# COUNTY COUNCIL'S RESPONSE TO CONSULTATION ON THE FOLLOWING DEVELOPMENT PROPOSAL

**Application No:** 18/00484/OUT

**Proposal:** Outline planning permission for up to 75 homes, pedestrian and cycle routes, creation of new access point from Charlotte Avenue, provision of open space, play space, allotments, orchard, parking and associated works.

**Location:** Land North and Adjoining Home Farm Banbury Road B4100 Caversfield

Fig 5.1 - Access and Movement Parameter Plan

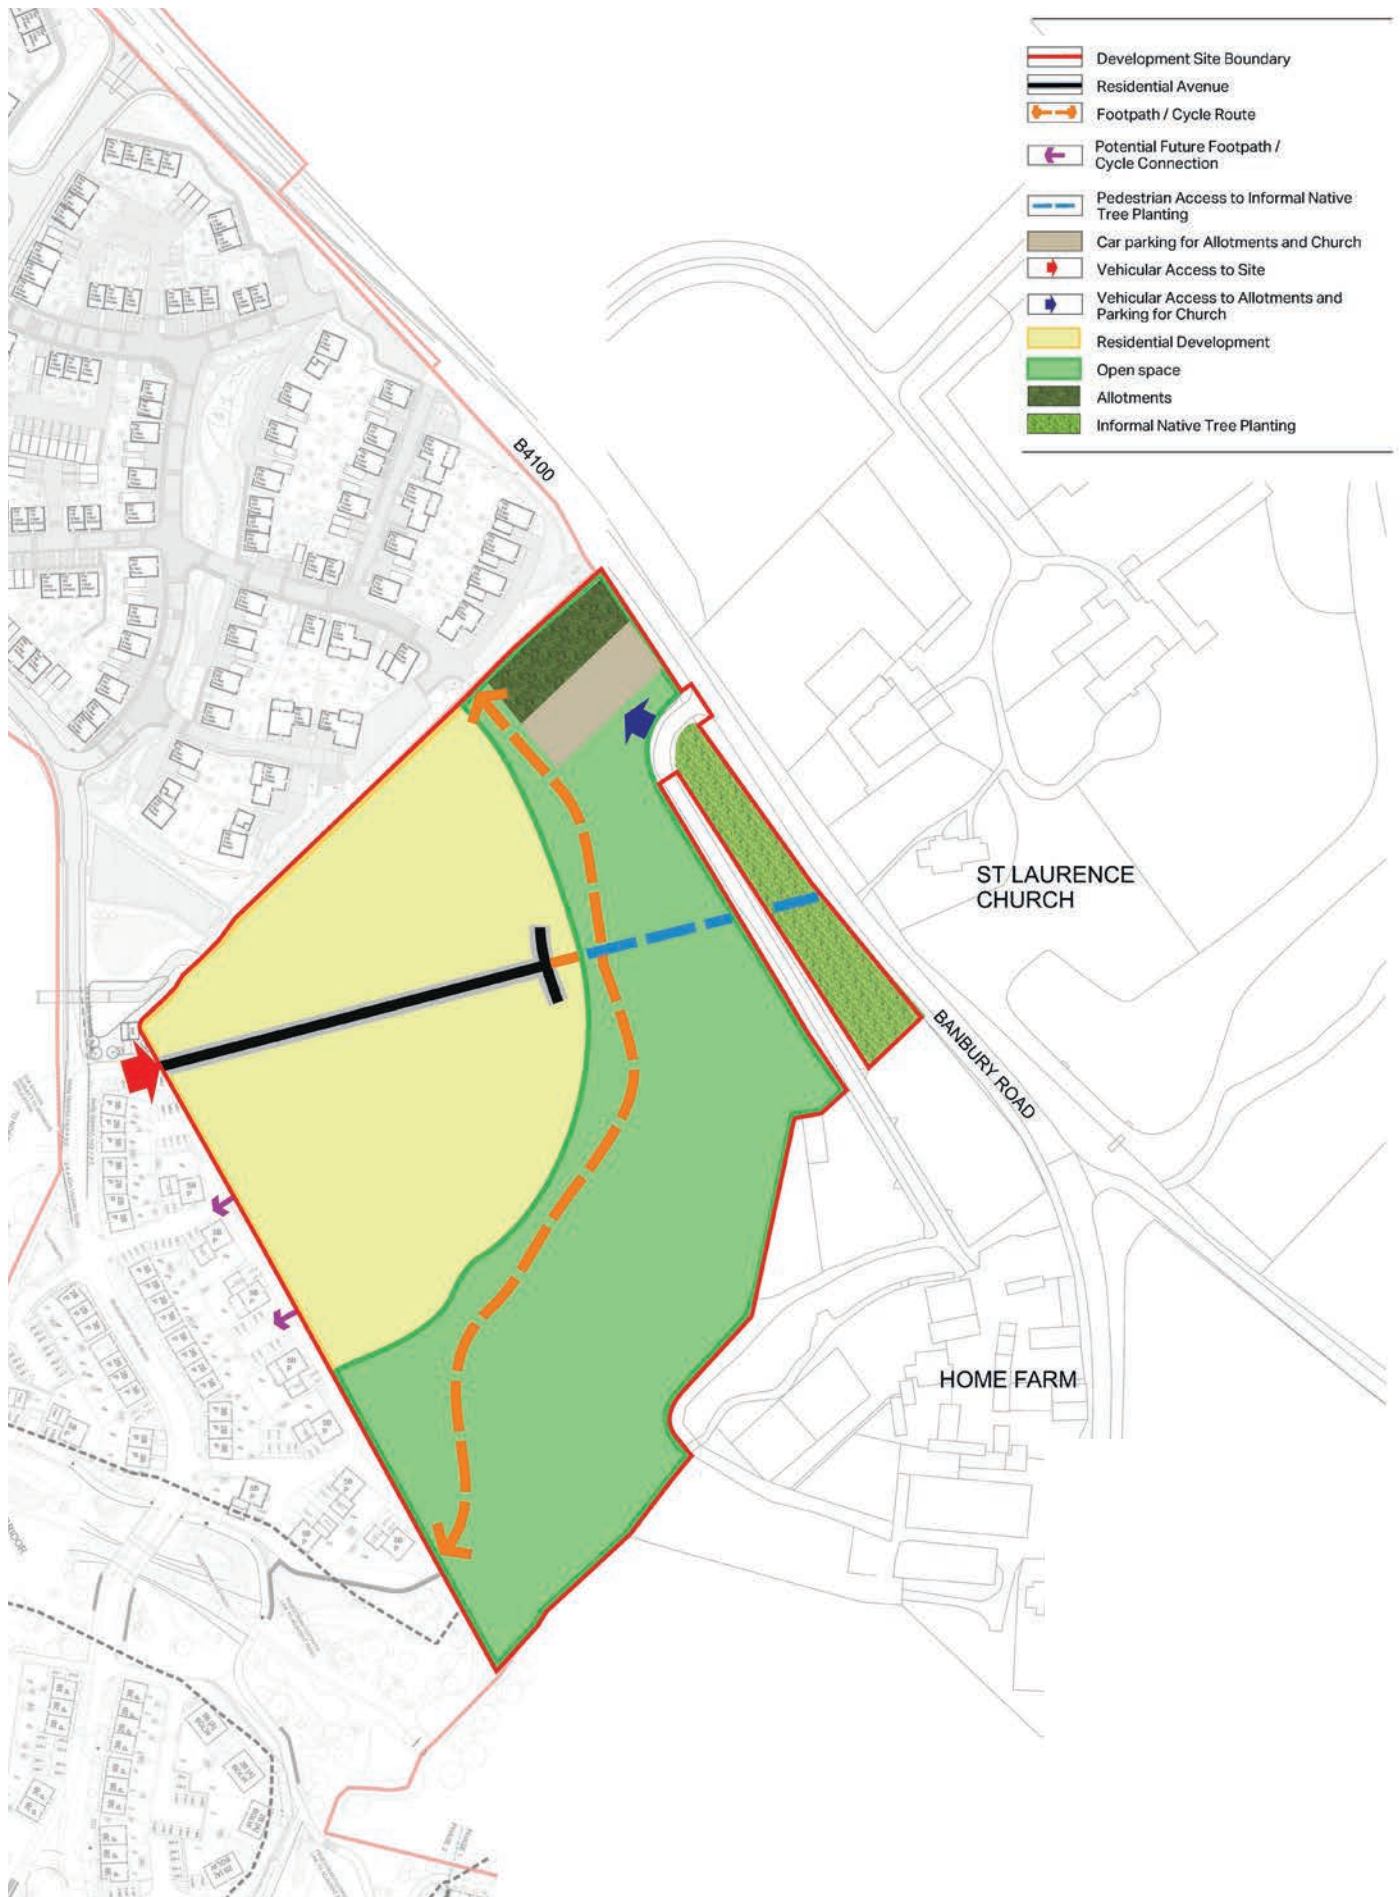
It is proposed that the main access road would have footways either side of 1.8m width. OCC would prefer to see these at 2m to prioritise sustainable travel. A 'leisure' footway/cycleway is proposed around the perimeter of the built up area of the site. OCC would prefer to see this designed as a functional route, connecting as directly as possible to the adjacent network.

Only two pedestrian connection points to adjacent parcels are proposed. This represents a missed opportunity for a level of permeability which is in keeping with the sustainable travel policy requirements of the Eco Town, and should be addressed by including additional connection points. Connection points towards the current bus stops are particularly important to look at, to ensure all properties are within a 400m walk of the bus stops. Such connection points should not be left to reserved matters stage but included on the access parameter plan in order to ensure that they are secured. **Reason for objection.**
